UNSW Cliffbrook Campus

JHA's Response to Acoustic Review

Title	JHA's Response to Acoustic Review
Project	UNSW Cliffbrook Campus Redevelopment
Description	Response to DA review
Key Contact	RO

The following addresses the review prepared by Andrew Beatty of Beatty Legal letter dated 31 July 2017 on behalf of nearby residents of UNSW Cliffbrook Campus Proposal, and a review of JHA's Acoustic report for Development Application by Brian Clarke of Wilkinson Murray included with the letter.

# Logger 1 - UNSW Cliffbrooke

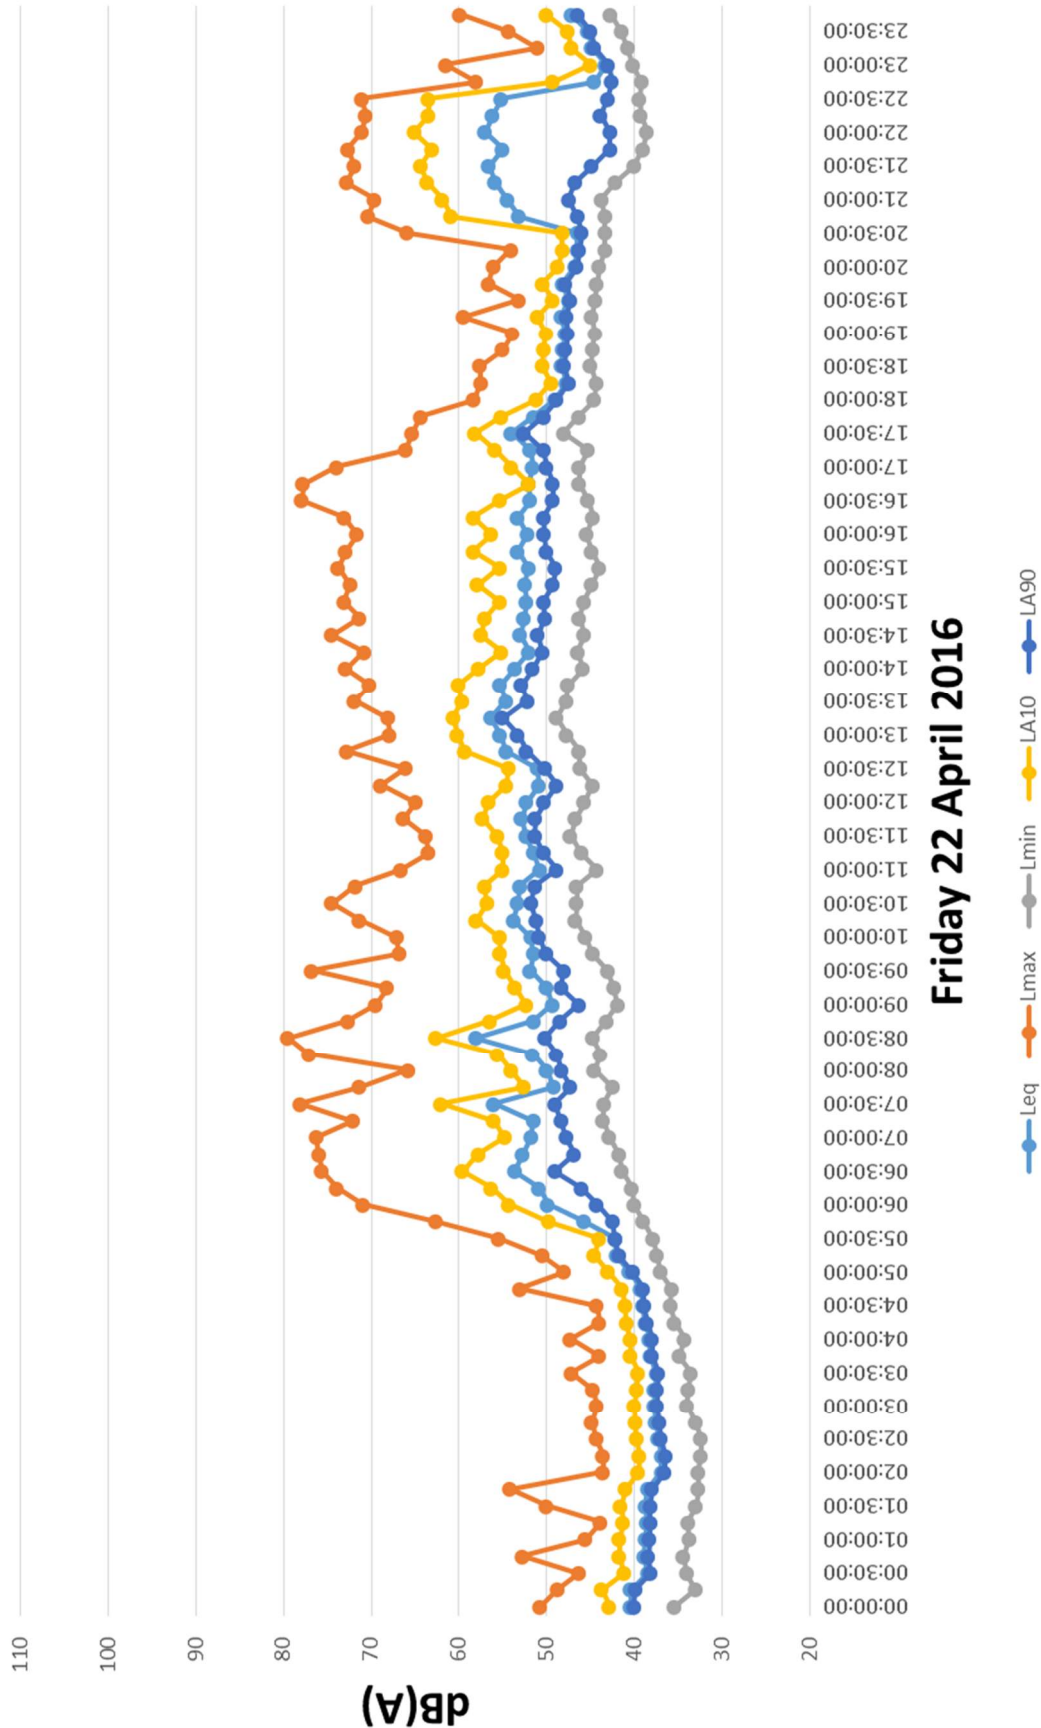
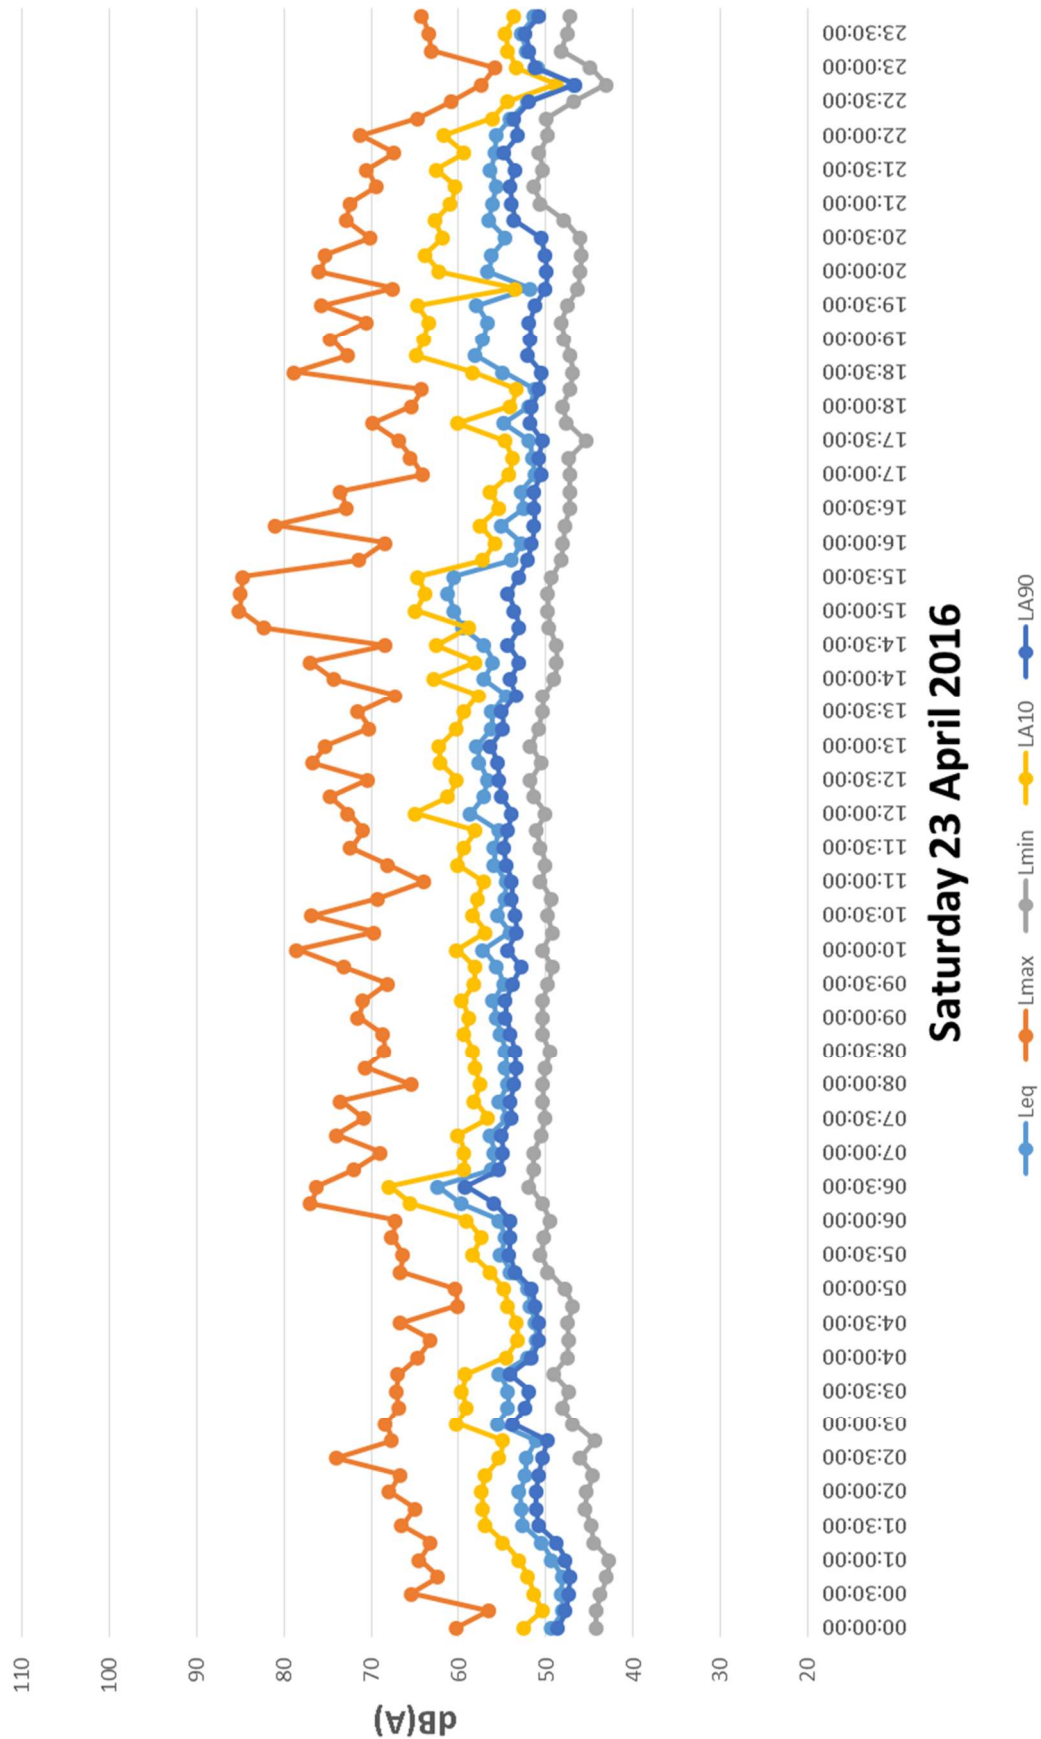
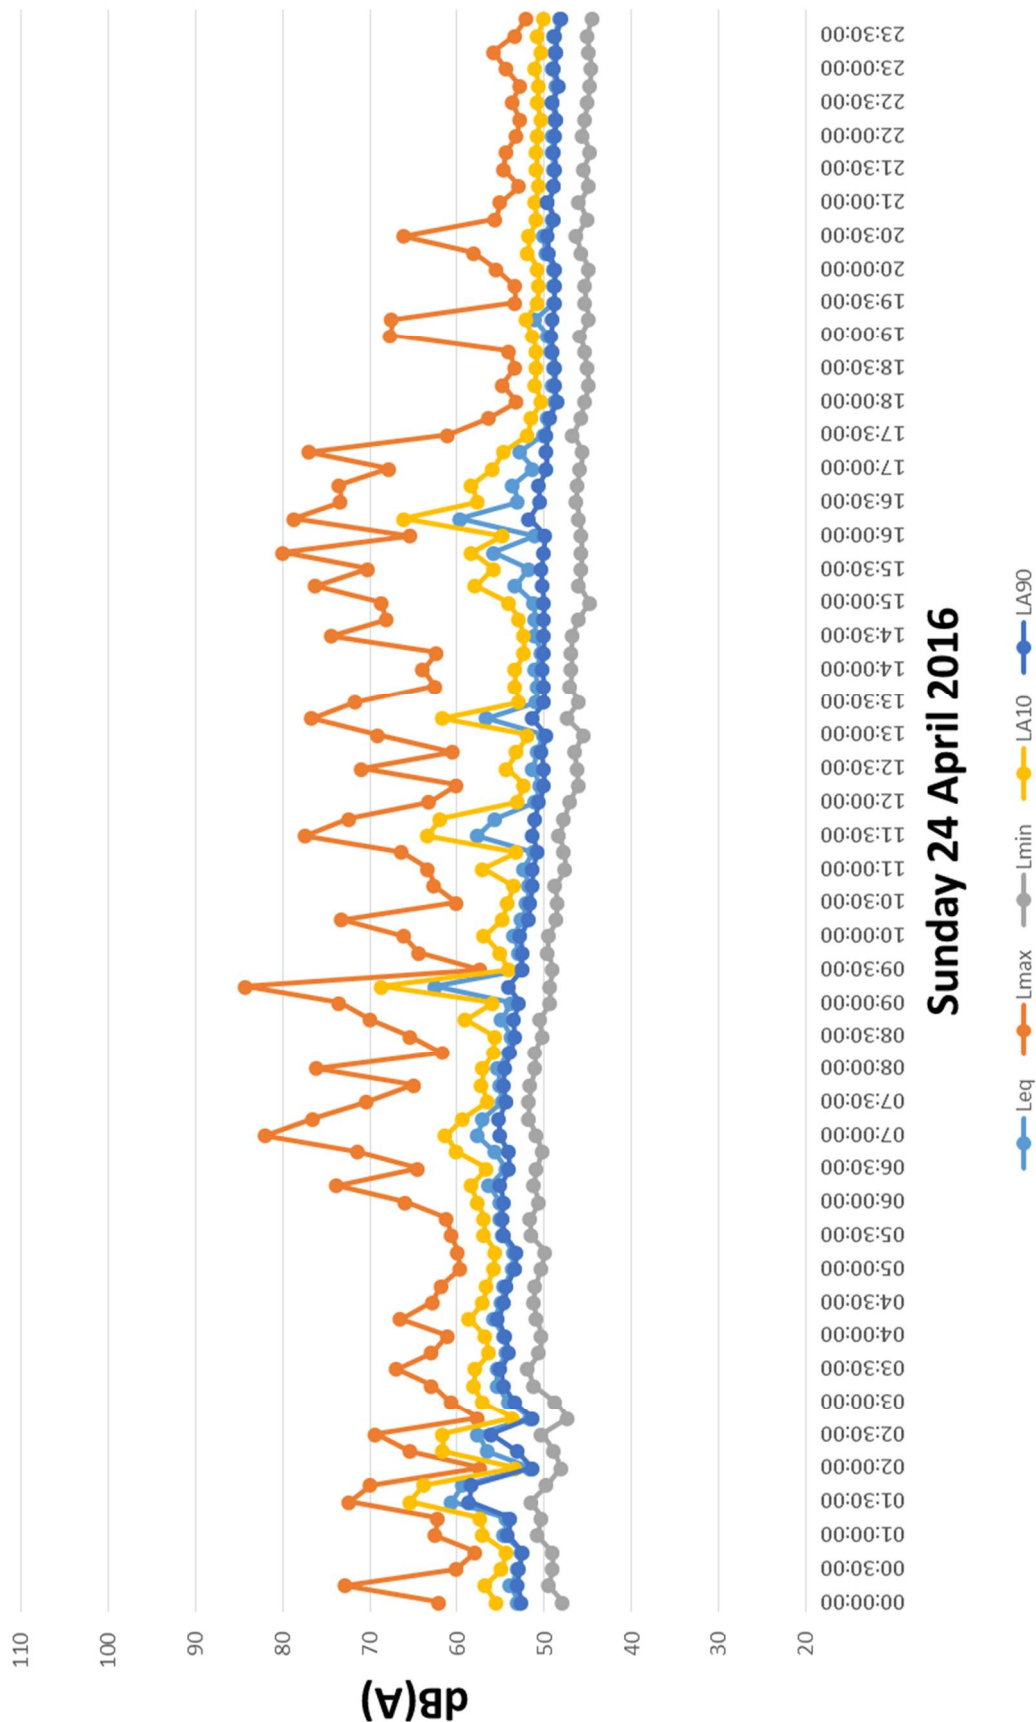
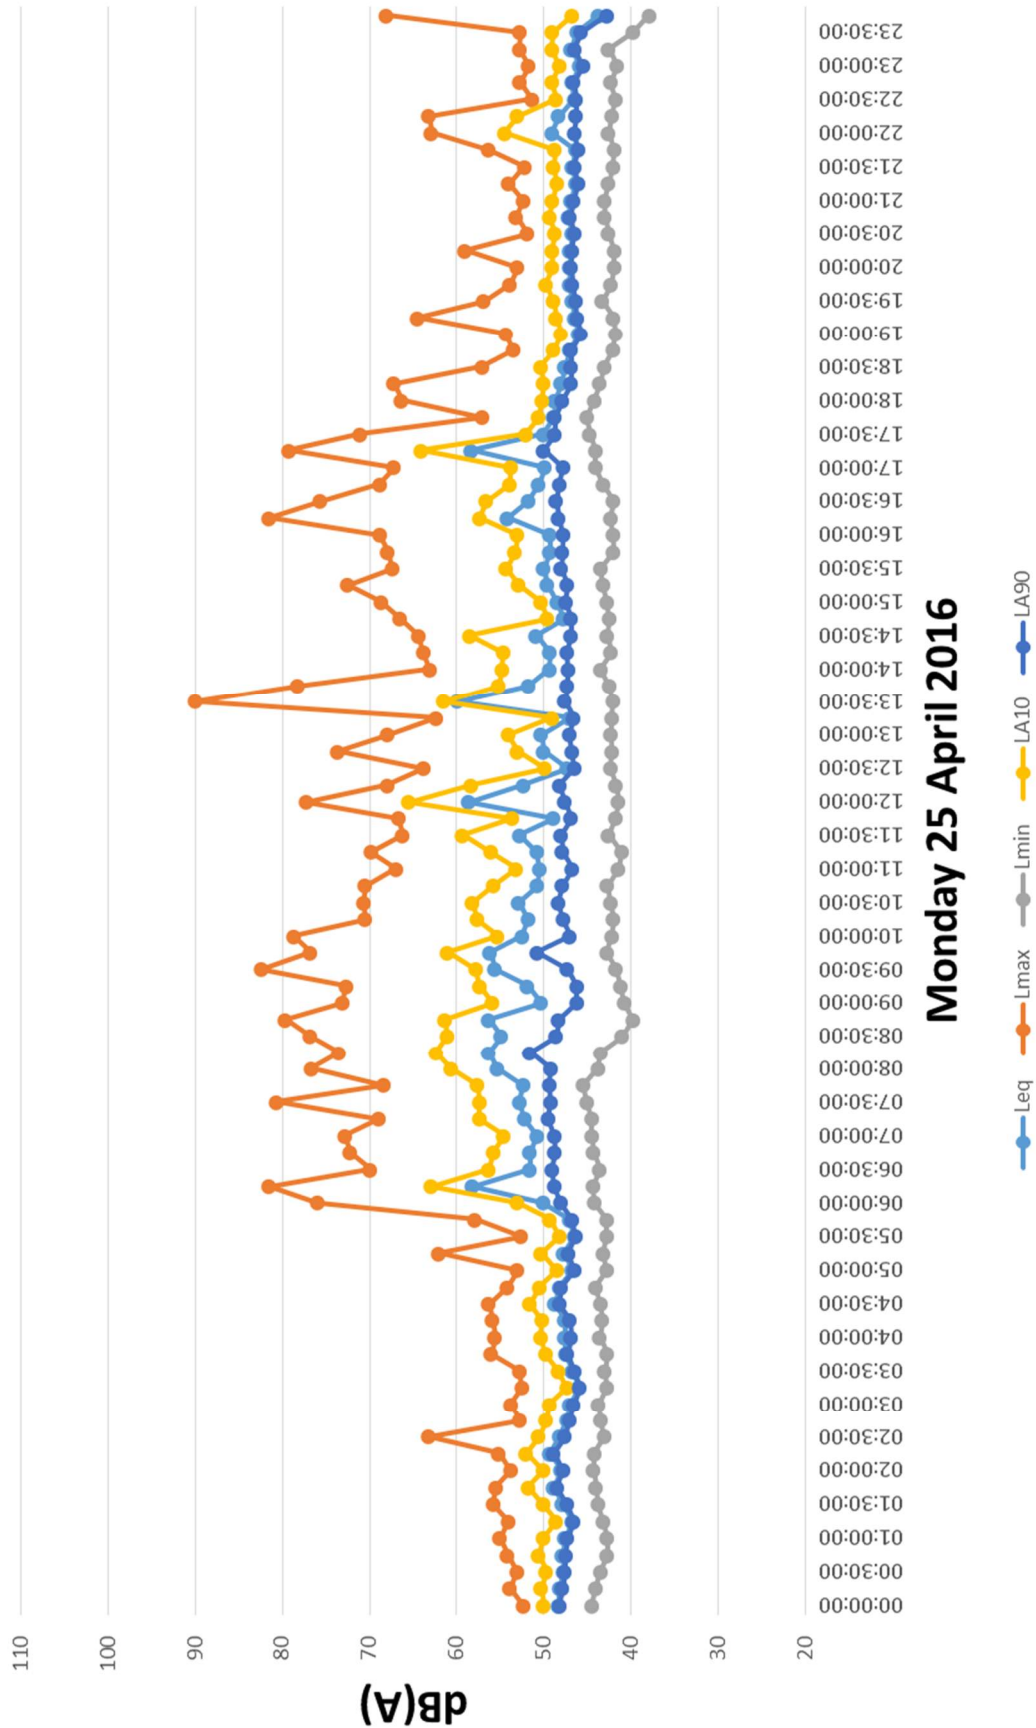
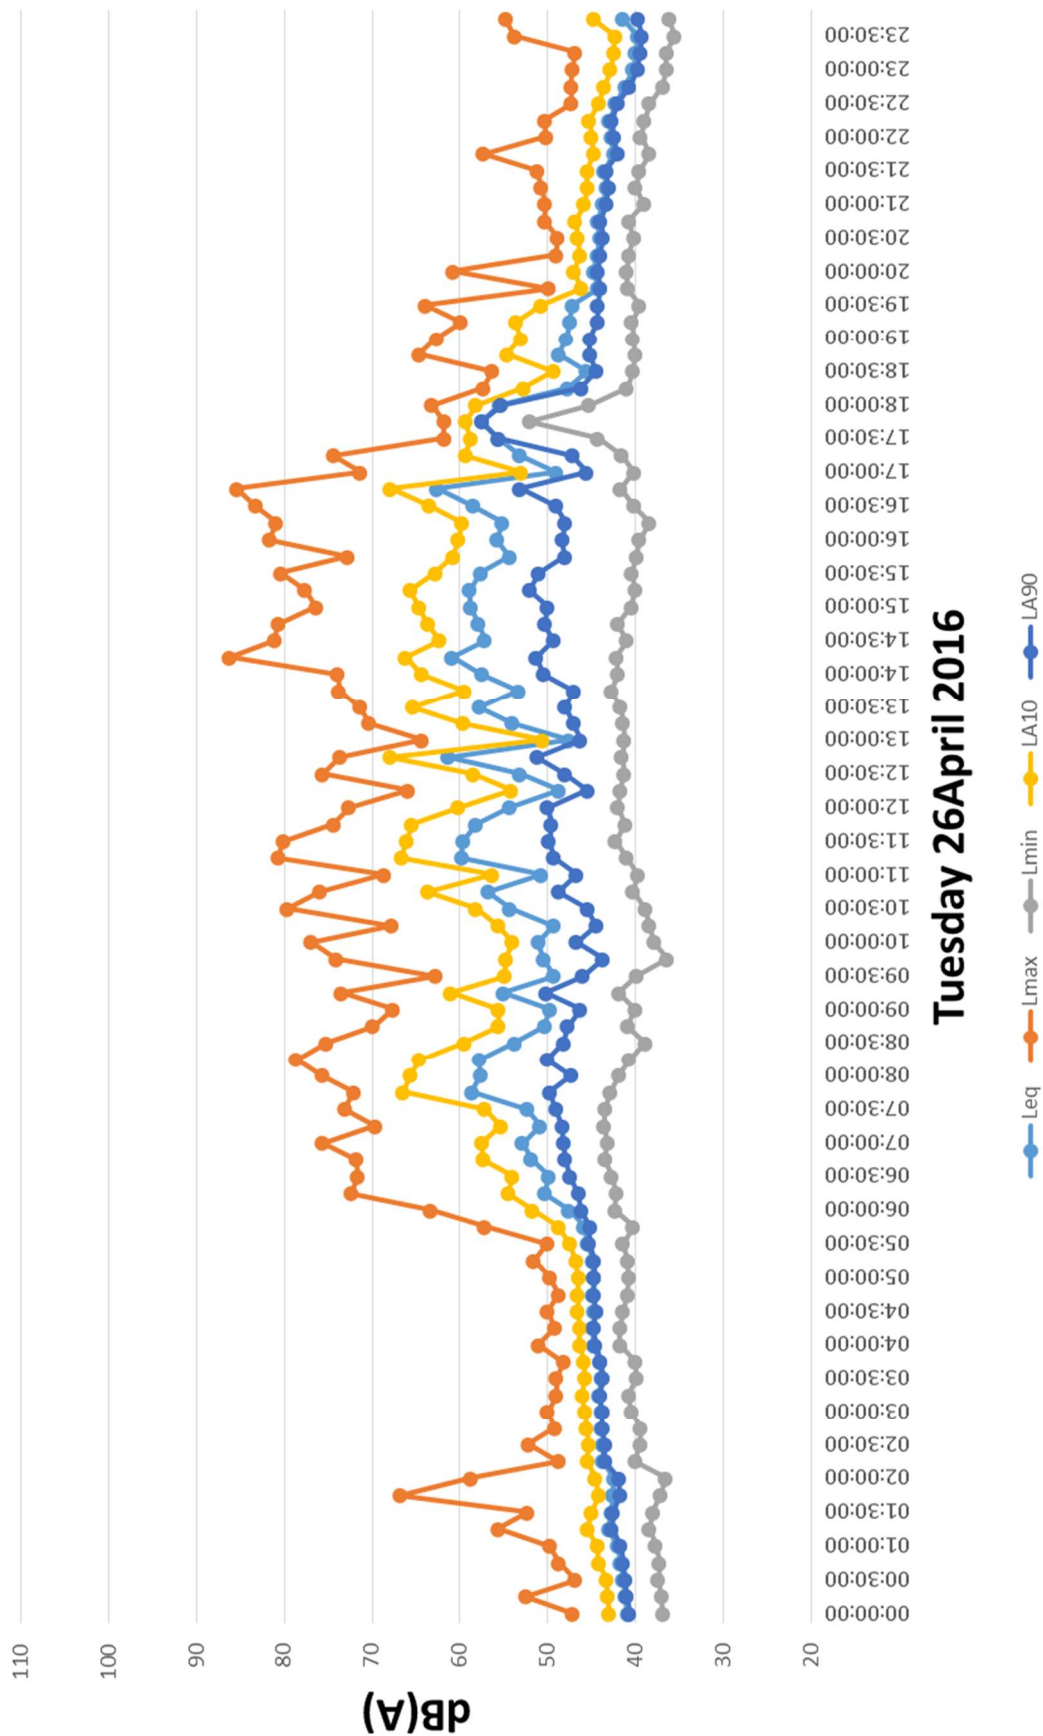
Unfortunately, the results of noise logging appear to be contaminated in that noise levels measured by the logger are much higher than those measured by JHA in the surrounding streets or by myself when on site. For example, street attended background noise measurements in the day were reported to be 42 dBA whilst noise data from the loggers for the day is reported to be 53dBA, this is a significant difference. In addition, my measurements in the afternoon were in the order of 38 dBA compared to the reported logger noise levels.

Furthermore, the fact that night L_{Aeq} and L_{A90} noise levels are reported at the same level further indicates that the noise logger data is unreliable and not suitable for the establishment of site specific noise criteria. Therefore, it can be concluded that correct site-specific noise criteria, both for construction and operation, has not been established therefore no correct assessment can be conducted on the development. As such the potential impacts or appropriate mitigation measures cannot be established.

Wilkinson Murray was comparing the measurements made at Battery Street (where the University does not share a boundary with No.12 Battery St) with the “ocean-front” side where the university does share a boundary with No.12. The logger measurements reflect the continuous noise from the ocean, not from ‘contaminated noise results’. Refer to the circled logger location and plan above taken from the JHA report dated 8 May 2017. Additional logger measurements were made to show that the measurements are not ‘contaminated’ as asserted by Wilkinson Murray. These additional results are included at the end of this report in Section 2.

The logger L_{Aeq} and L_{A90} noise level measurements from the JHA report dated 8 May 2017 reflect the continuous noise from the ocean, not from contaminated noise results. Hence the closeness of the L_{Aeq} and L_{A90} noise levels, not from contaminated noise results.

The location of the logger, near the ocean, resulted in similar results for L_{Aeq} and L_{A90} . This is because the ocean is a relatively constant source of noise, so the documented L_{A90} (lowest 90% of levels in the measurement period) result is similar to the overall L_{Aeq} . The additional noise measurements, located further from the ocean, document similar L_{Aeq} (overall noise) and a greater difference in L_{Aeq} and L_{A90} , which is to be
